From: Simon Davis
Sent: 04 March 2019 17:12
To: 'Charlotte Grant' [REDACTED]
Subject: FW: BR-270-18

From: Jamie Brown [REDACTED]
Sent: 04 March 2019 14:42
To: Simon Davis <Simon.Davis@arun.gov.uk>
Subject: BR-270-18

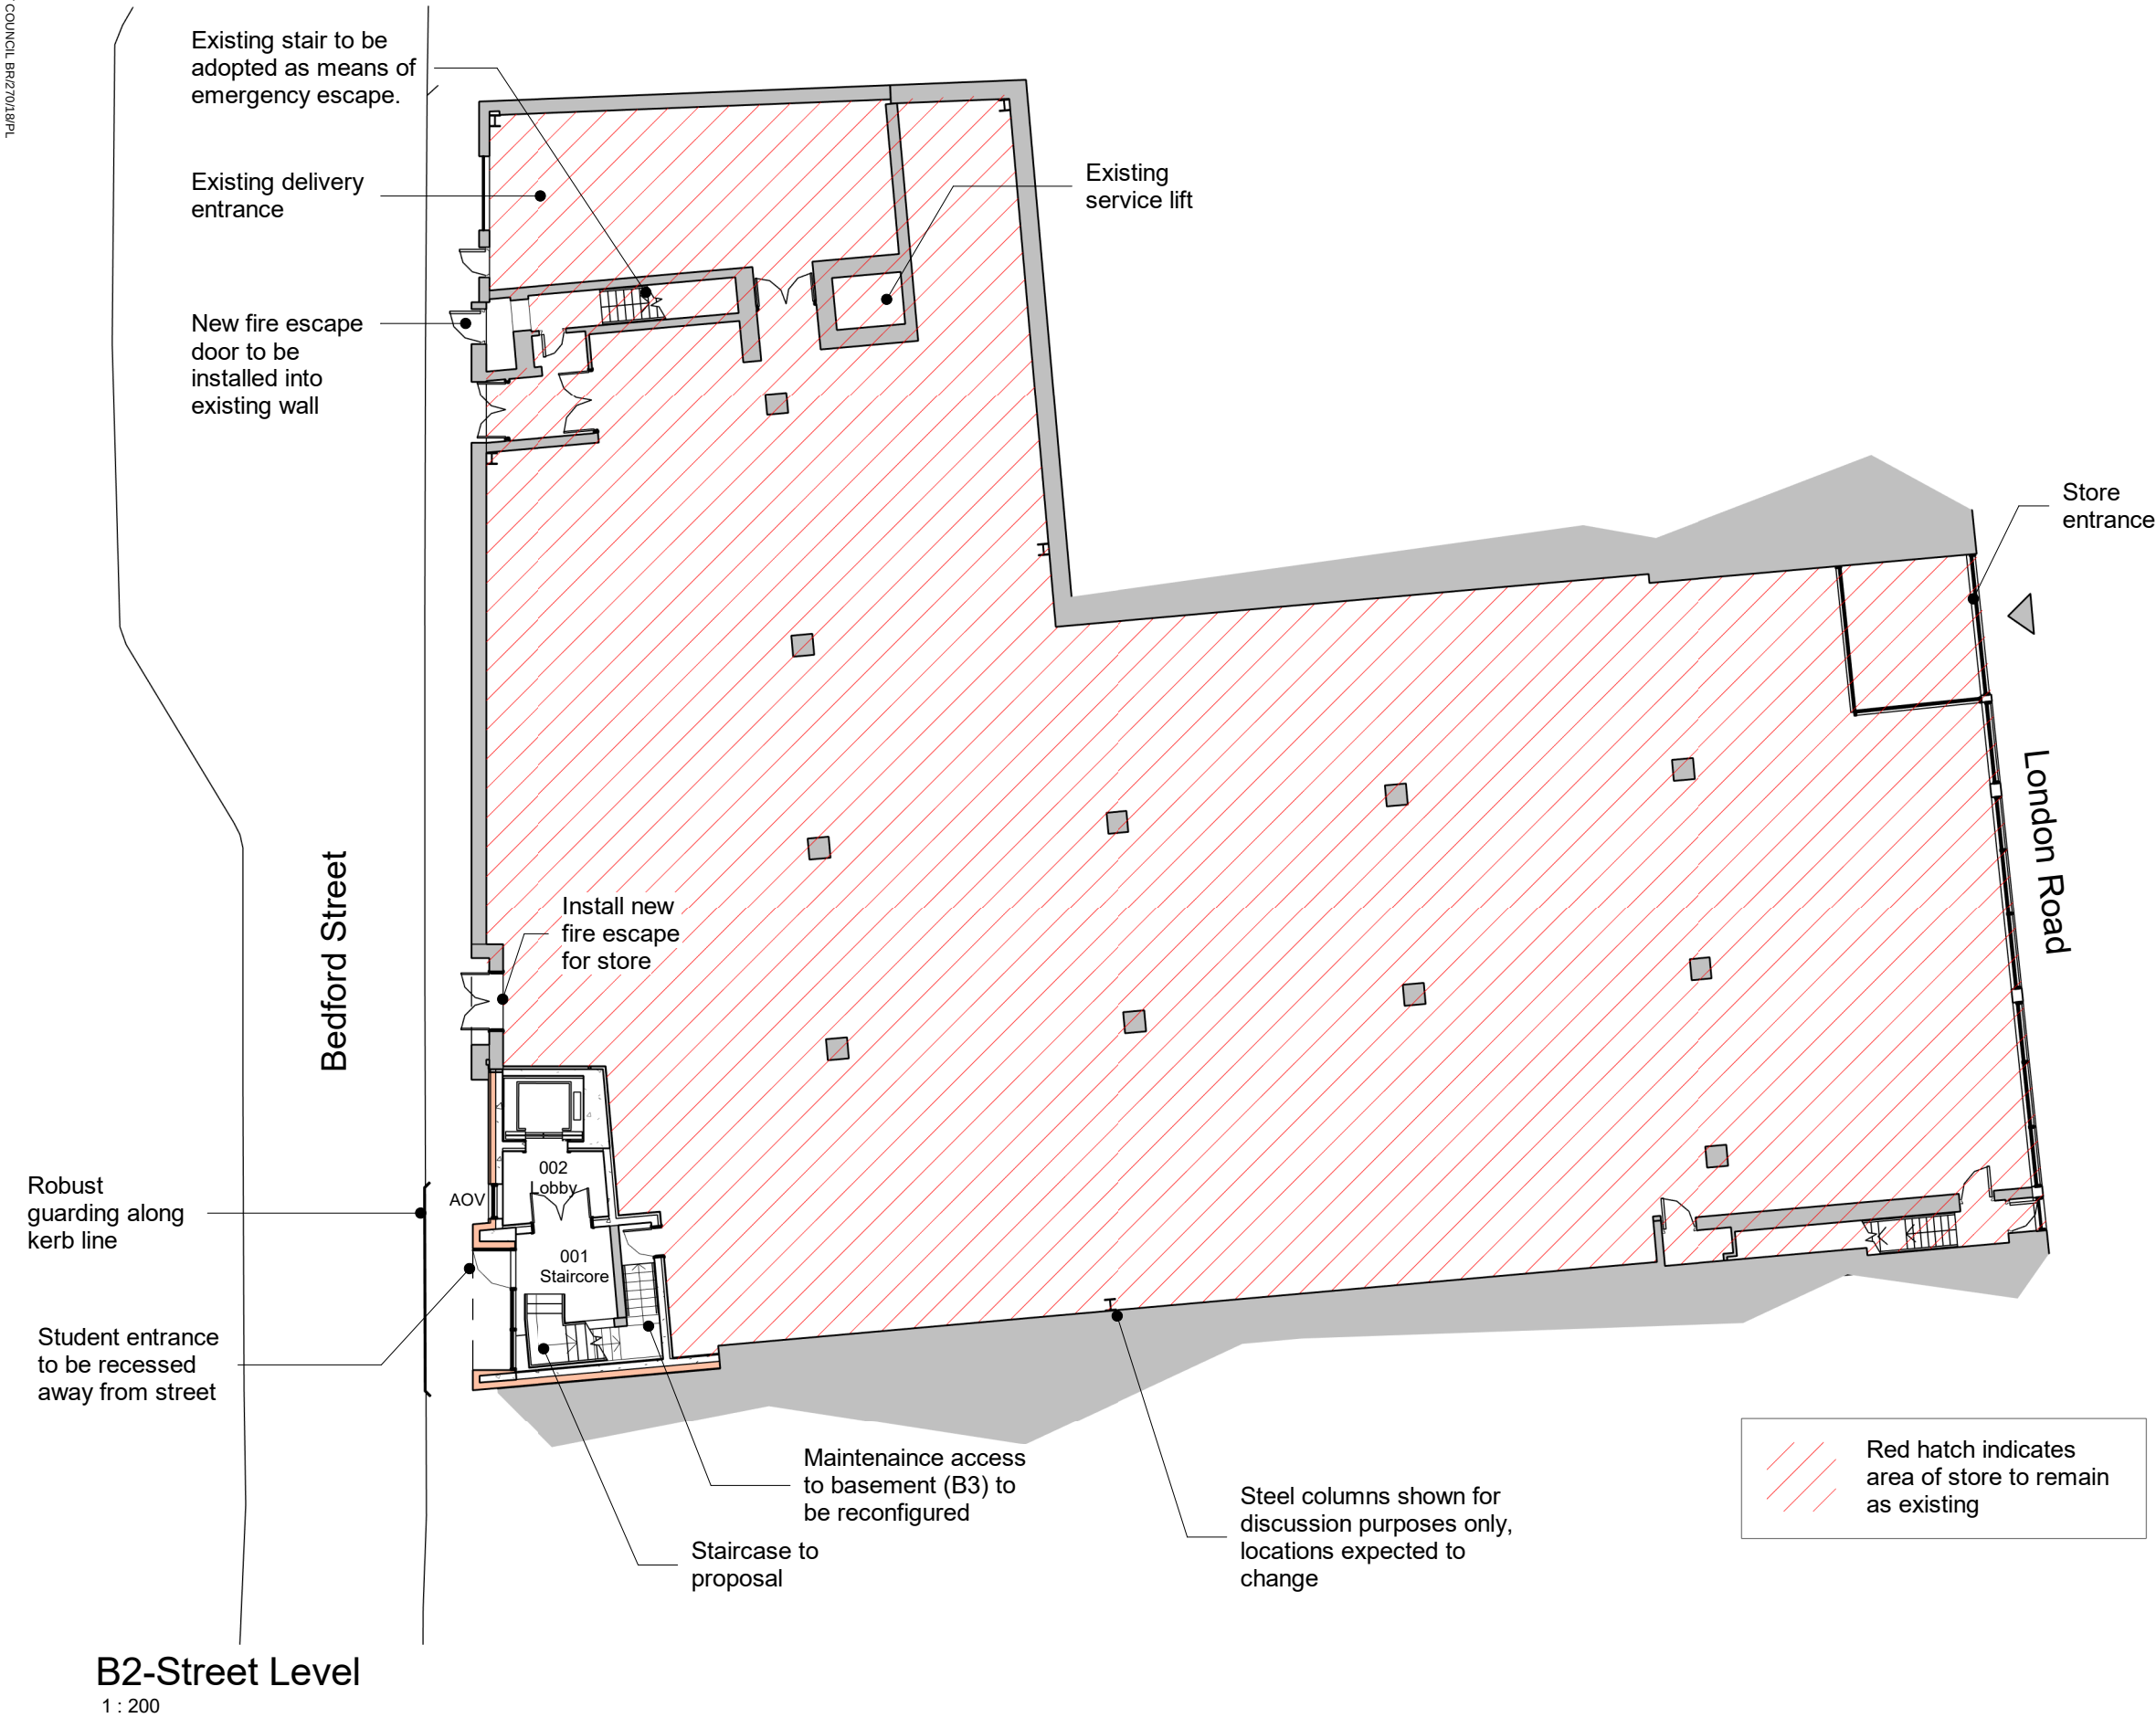
Thank you for your time earlier. As I said I am satisfied still with the general principle of development at the site. However I agree having re-assessed the Street Improvements Plan (P112 P1) there needs to be more detail in terms of widths of the build out to show that it will not affect the carriageway width detrimentally along Bedford Street. My concern here is this is already a narrow street and an additional build out may have a negative result and make the road tighter and restricted for vehicles travelling to the north and access to the disabled parking bays (outside Morrison's) challenging.
